Subject: Environment Agency Response to: FG/206/17/PL

Our ref: HA/2018/120208/01-L01
Your ref: FG/206/17/PL
Date: 14 March 2018

INSTALLATION OF A SIX PUMP (12 FILLING POSITION) PETROL FILLING STATION, DRIVE-TO- PAY KIOSK & ASSOCIATED WORKS INCLUDING JET WASH, AIR/ WATER SERVICES & VACUUM EQUIPMENT

LAND AT ASDA SUPERSTORE LITTLEHAMPTON ROAD FERRING BN12 6PN

Cross Section Showing the Proposed USTs Location
 Vertical Scale: 1:85 Horizontal Scale: 1:263
 E13043/2: ASDA Worthing Ferring
 Prepared For: ASDA Stores Limited

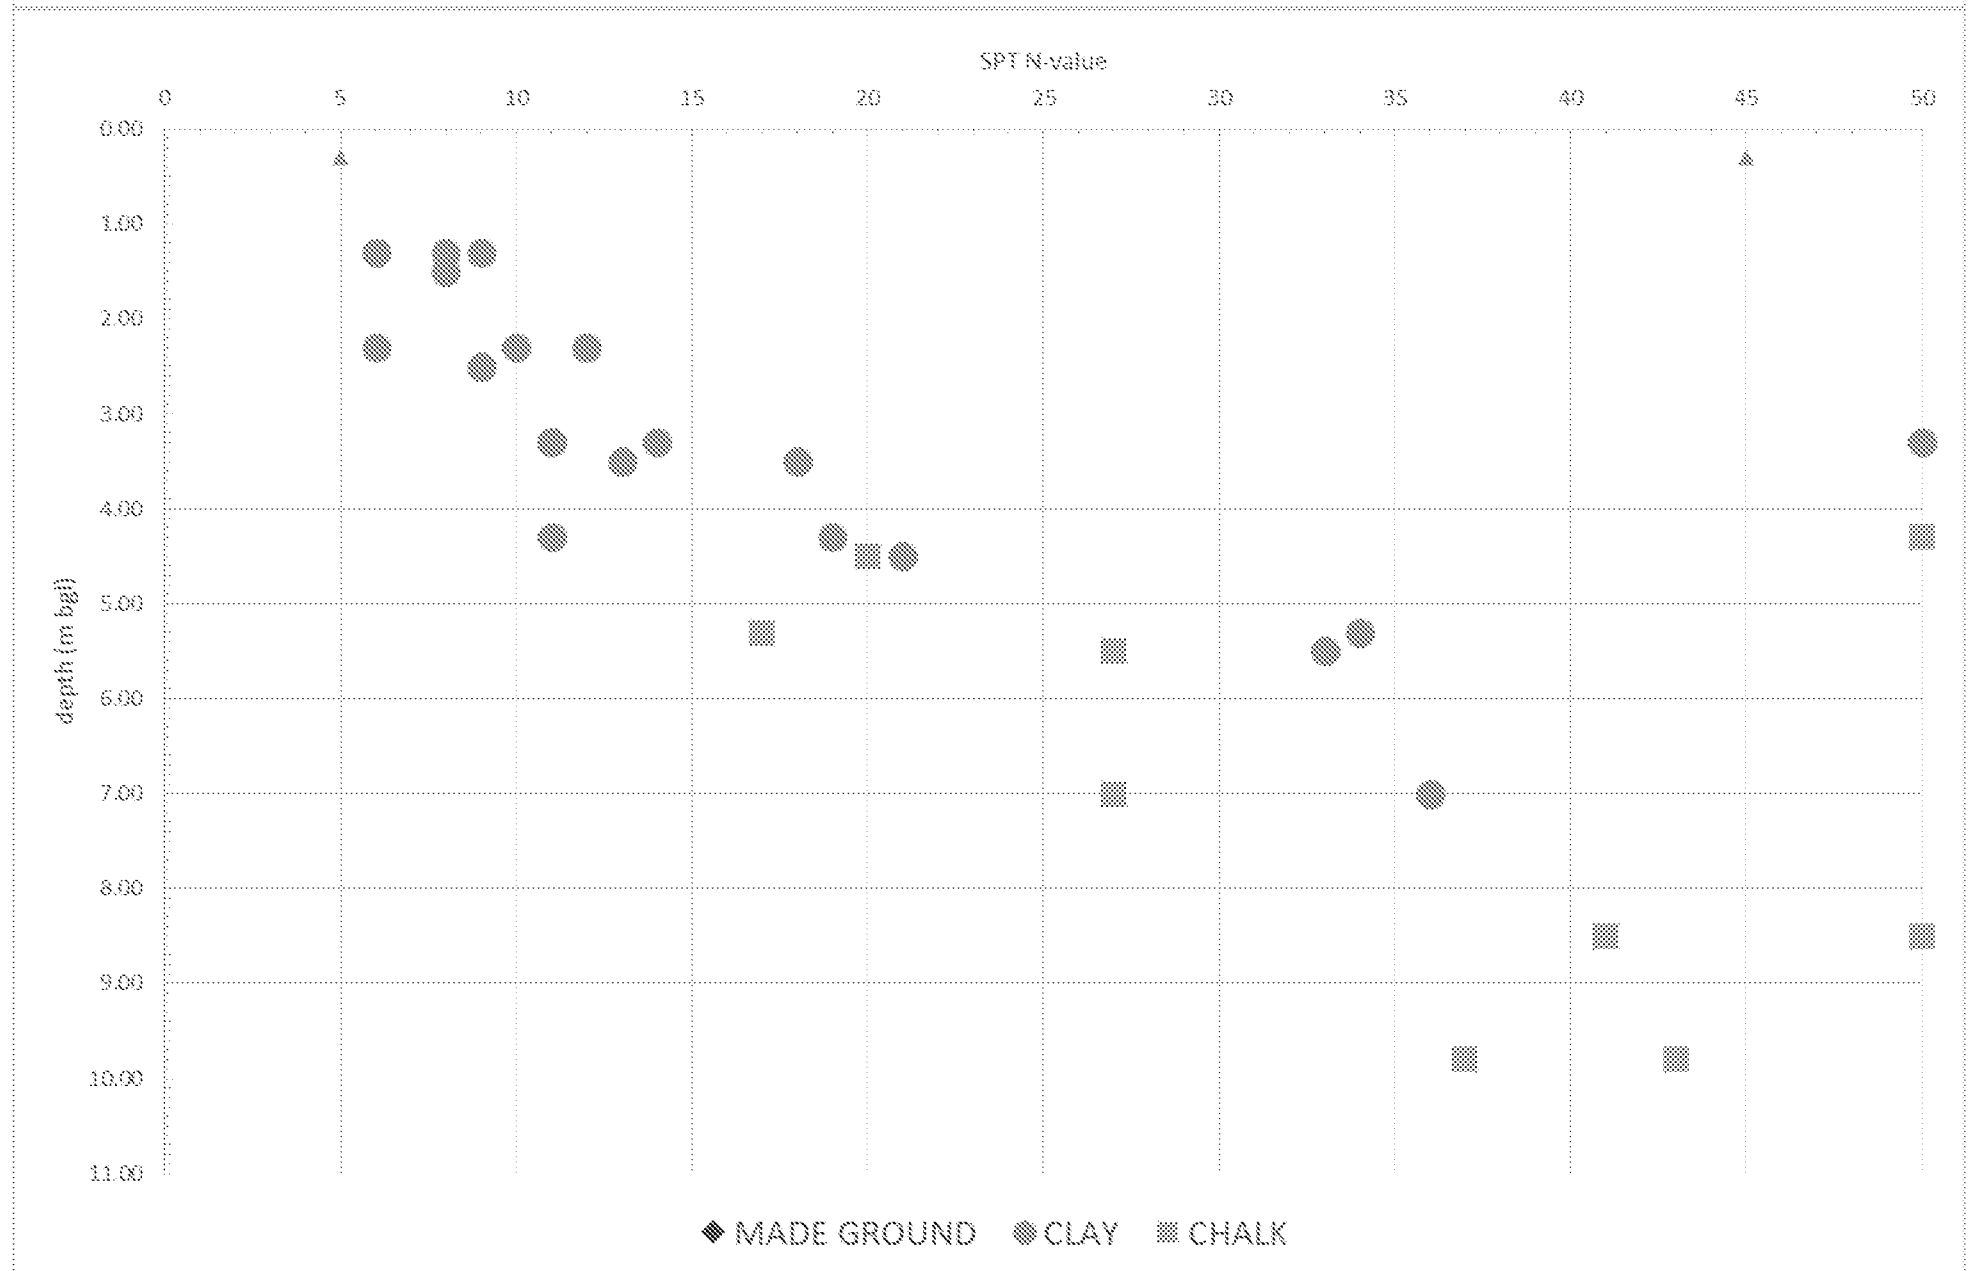
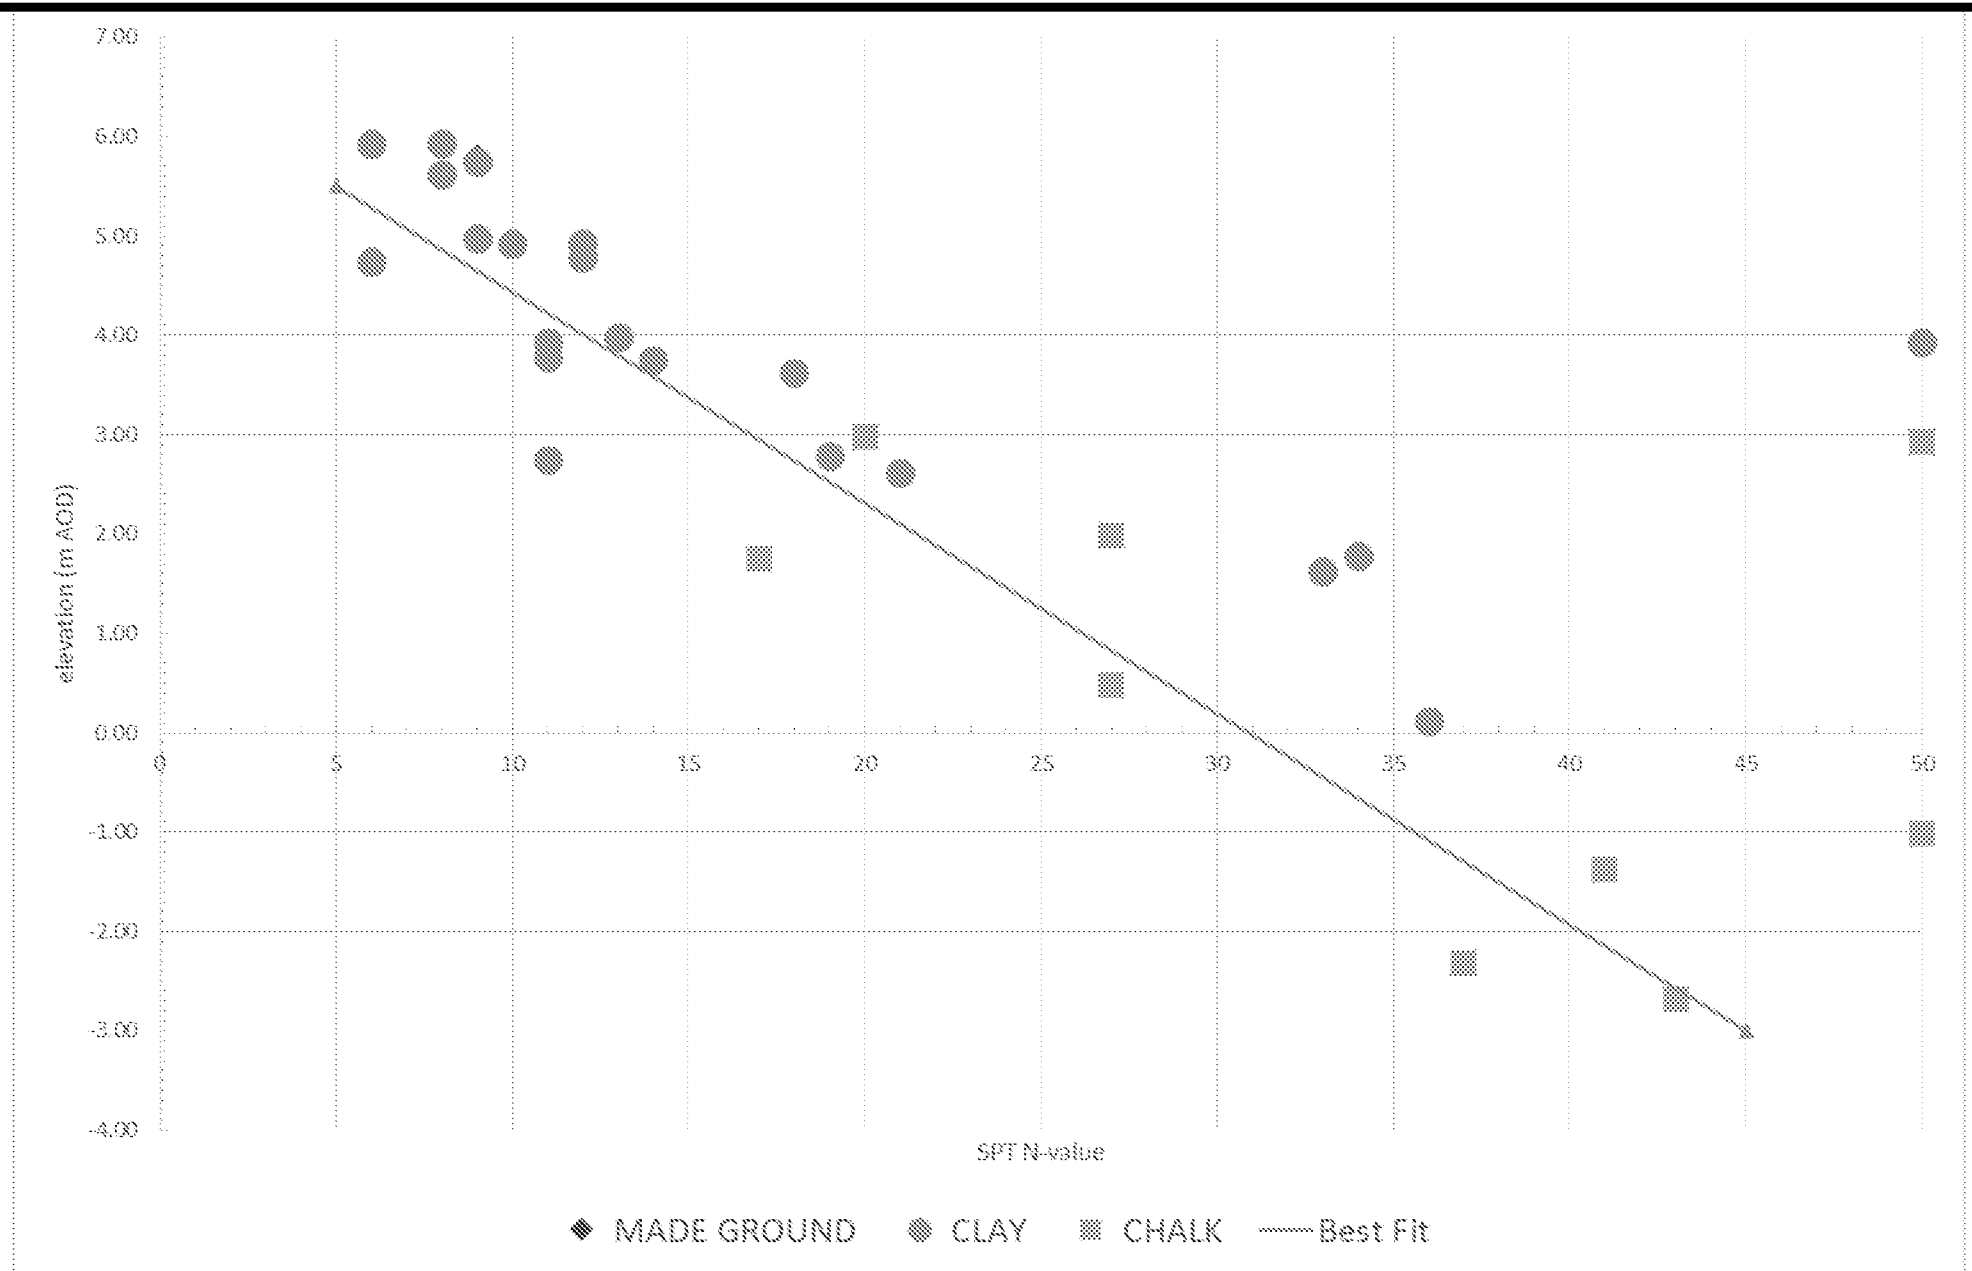
The proposed design of the underground tanks is inadequate. As the proposed tanks are to be developed below ground, groundwater levels may be such that they are sited below the groundwater table. We therefore recommend that the applicant addresses this environmental risk, particularly with our Position Statement D2 and present a design that mitigates against any future pollution.

The development hereby permitted shall not be commenced until such time as a scheme to install, monitor and maintain the underground tanks has been submitted to, and approved in writing by, the local planning authority.

The scheme shall include the full structural details of the installation, including details of excavation, the tank(s), tank surround, tertiary containment, associated pipework, monitoring system and maintenance, monitoring & sampling schedule. The scheme shall be fully implemented and the tanks and associated infrastructure subsequently maintained and monitored, in accordance with the scheme, or any changes as may subsequently be agreed, in writing, by the local planning authority.

Existing Site Section with Borehole Logs

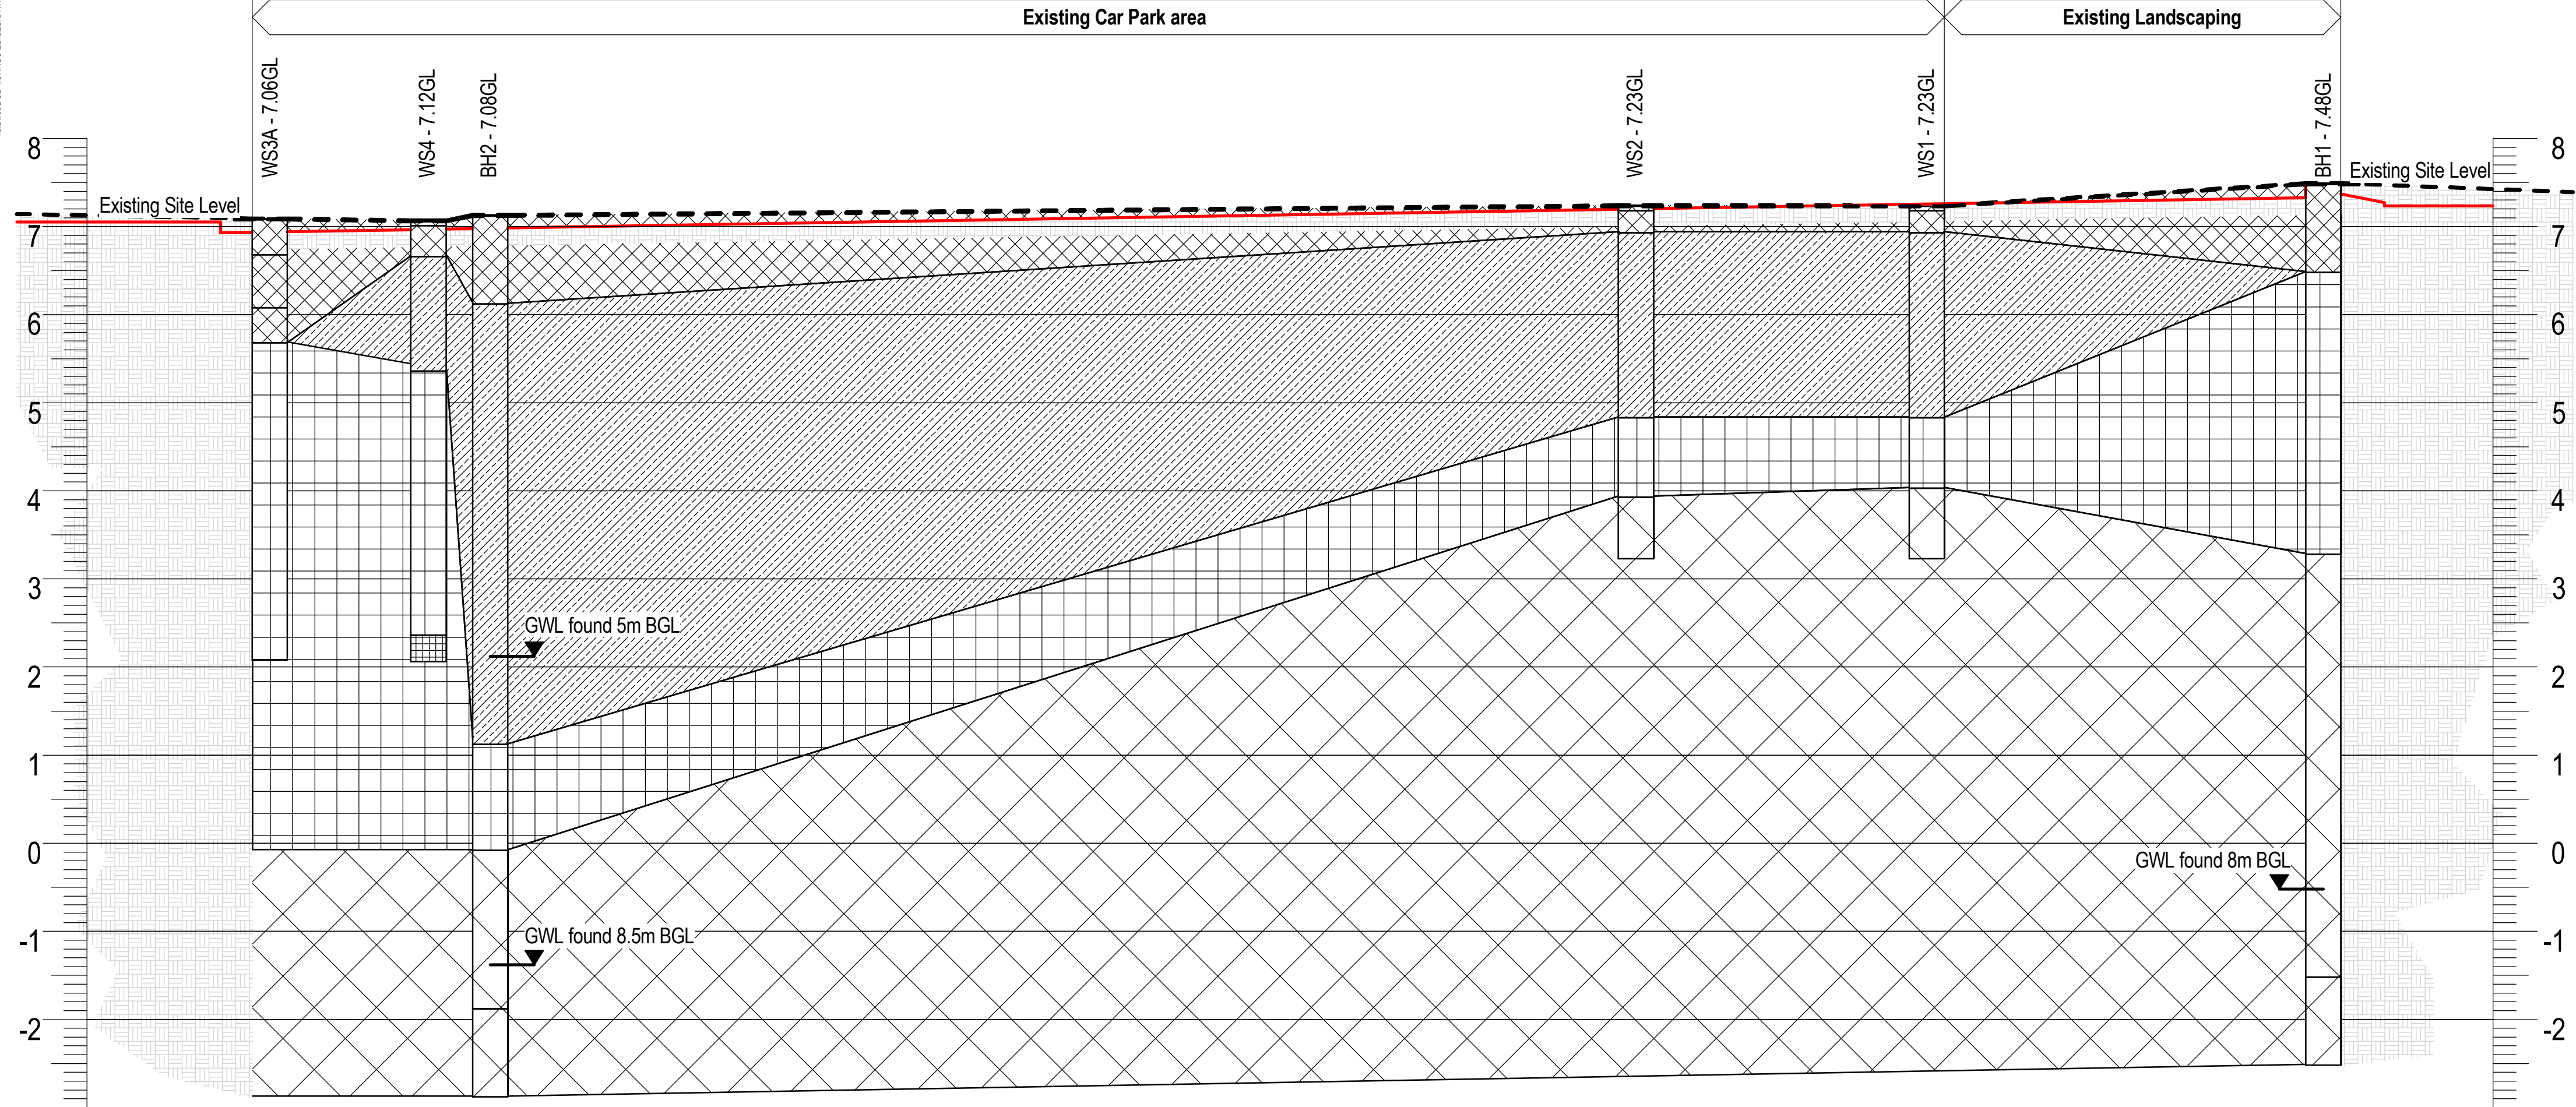
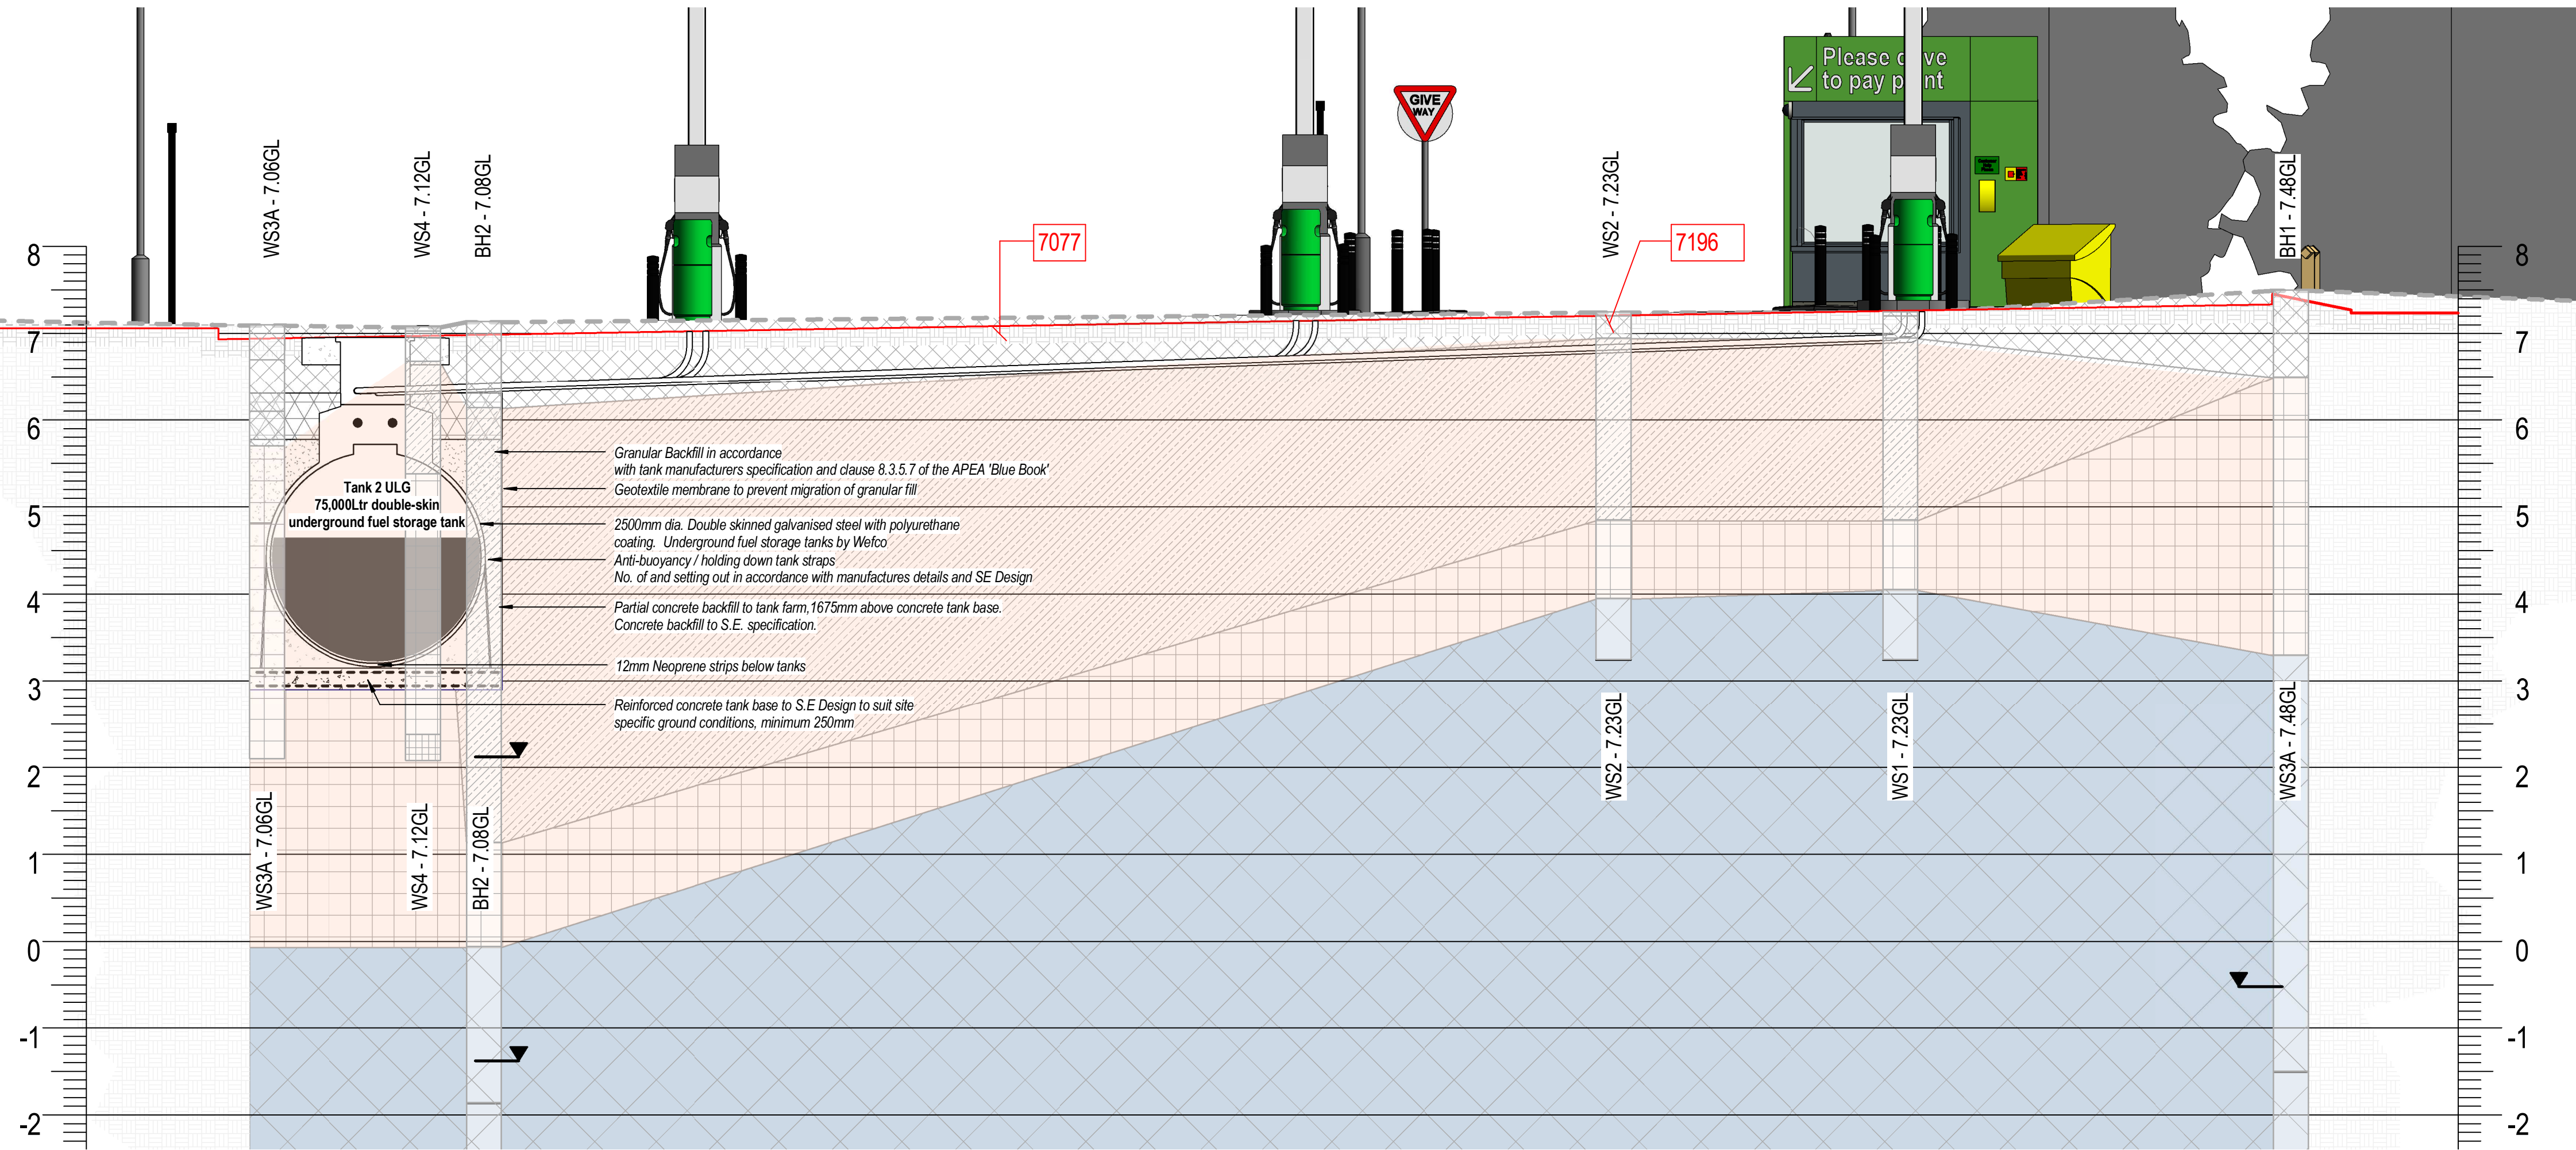
The site is underlain by a Secondary A aquifer (River Terrace Deposits) followed by a Principal aquifer (Undifferentiated Chalk Formation). Groundwater levels are also shallow within the area. The environmental sensitivity at the site is therefore considered to be very high. The future use could present potential pollutant linkages to the water environment. Consideration for the risk posed by surface water drainage will also need to be undertaken.
